Our ref: DOC22/747958
Your ref: SSD-36778089

Subject: Advice on EIS - Ryde Hospital Redevelopment (SSD-36778089) (City of Ryde)

The biodiversity development assessment report (BDAR) prepared by Ecological Australia, dated 22 July 2022 has been reviewed and EHG raises the following comments in relation to biodiversity impacts.

Table 5 Schedule of TPZ encroachment, resulting impacts & recommendations.

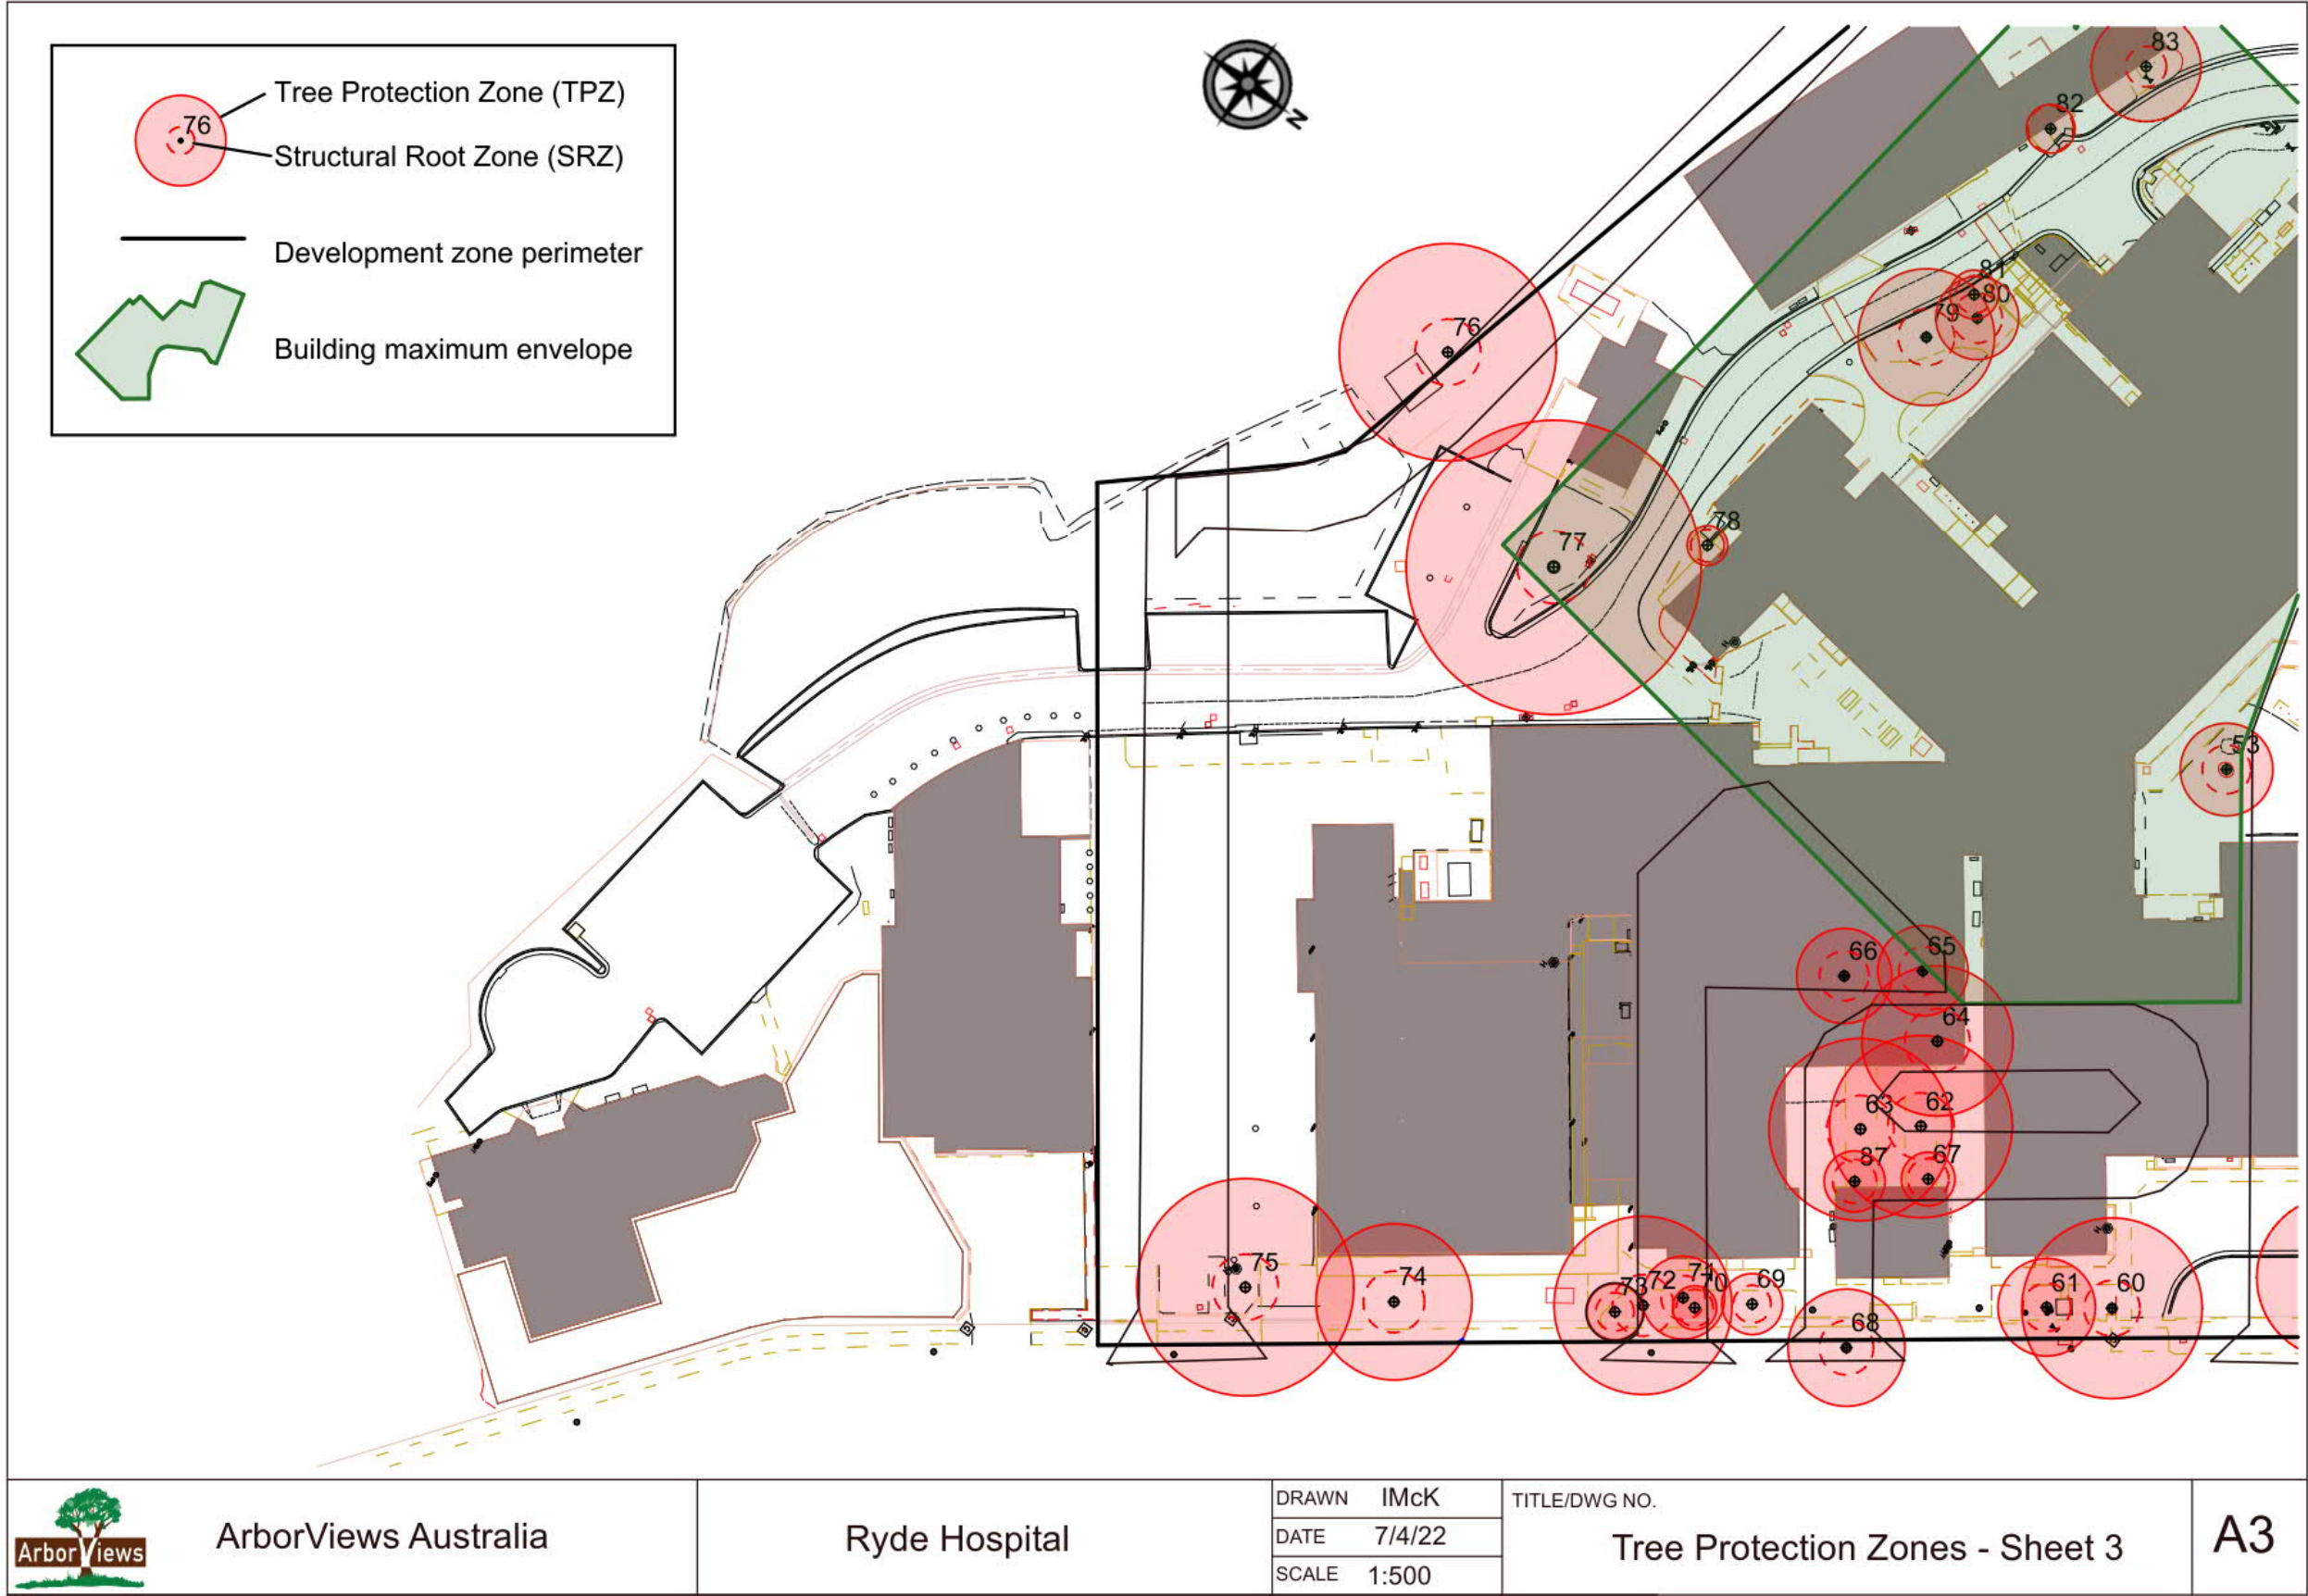
- Appendix 4: Site Plans with TPZs & SRZs of the AIA does not include all structures or works associated with the proposed development. EHG also considers it likely that there are additional trees on site that have not been mapped or included in the assessment, particularly along the edges of areas mapped as BGHF.

- An addendum to the AIA should be provided to address the above comments. A tree removal and retention plan based on the concept proposal and stage 1 layout should also be provided. Trees requiring removal and those to be retained and protection should be clearly identified on the plan. The location of any tree protection measures, such as TPZ fencing should also be identified on the plan.
